Subject: RE: Planning Consultation on: BR/190/20/OUT

Application ref: BR/190/20/OUT

Description: Outline application with all matters reserved for 10 No. new dwellings consisting of 1 No. 1 bed property, 8 No. 2 bed properties & 1 No. 4 bed property with associated services, landscaping, car parking & amenity (resubmission following BR/49/19/OUT).

Location: 26 Burnham Avenue Bognor Regis PO21 2JU

SITE PLAN (PROPOSED) 1:200

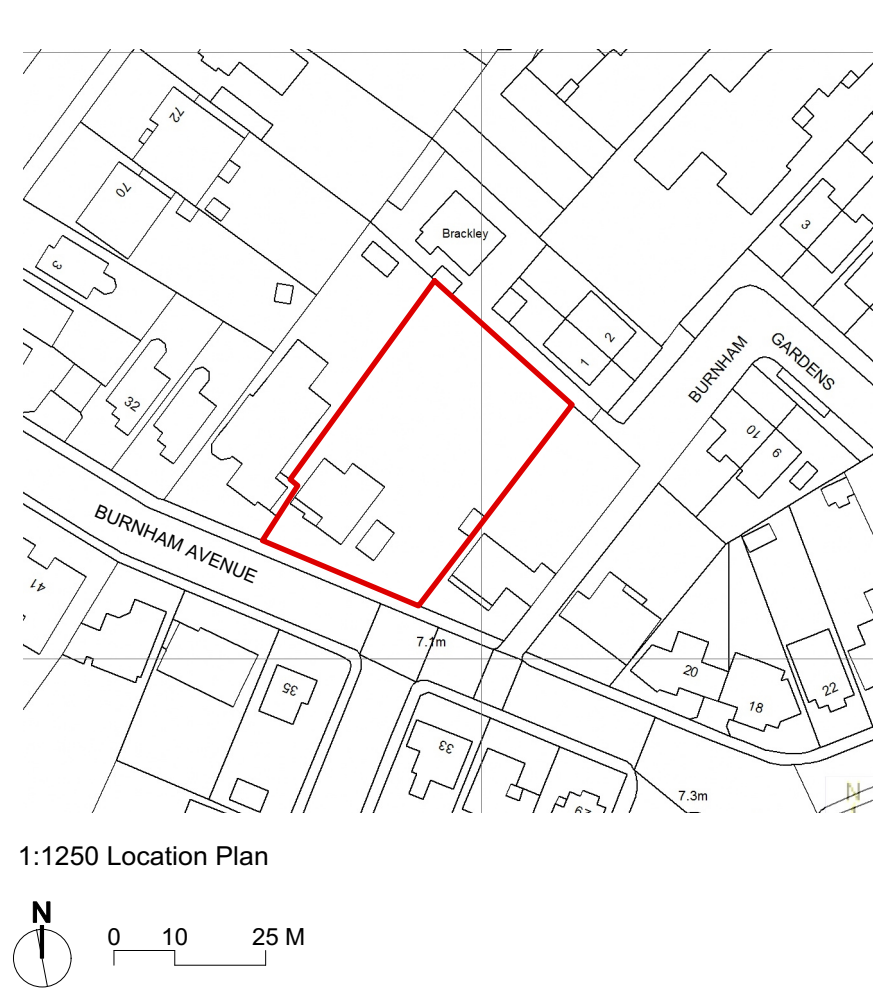
There would be considerable effect on the street scene with these proposals. The proposals indicate that some removal of greening to the frontage would be required for the development. The proposals show the retention of established trees within the rear of the property, these would require protection during construction if they are to remain undamaged. Any tree removals would need to be in consultation with Arun District Councils Tree Officer.

The existing trees in particular along the boundaries and to the north/east of the proposals provide potential valuable screening and could be compromised by these proposals. Root protection Areas (RPA) should extend into the development site and to those in neighbouring land. Before construction, a tree protection scheme must be in place for any adjacent trees whose root protection areas fall within the construction zone from neighbouring land. This should be in accordance with BS 5837:2012 'Trees in relation to construction'

There would appear to have been consideration within this application for communal amenity outdoor space which is good to see. There would be requirement for the submission of a landscape scheme which should be submitted for approval, detailing plant species choice, position, densities and size at time of planting. This should be plotted in plan and list form and in relation to the trees and vegetation to be retained in the locale, so that a clear picture of the proposals can be seen. These details are required to assure the proposals are appropriate to its setting and to ensure that appropriate screening is provided, maintaining and uncompromising the setting and ensuring that the proposals fit within the area of neighbouring and adjacent properties.
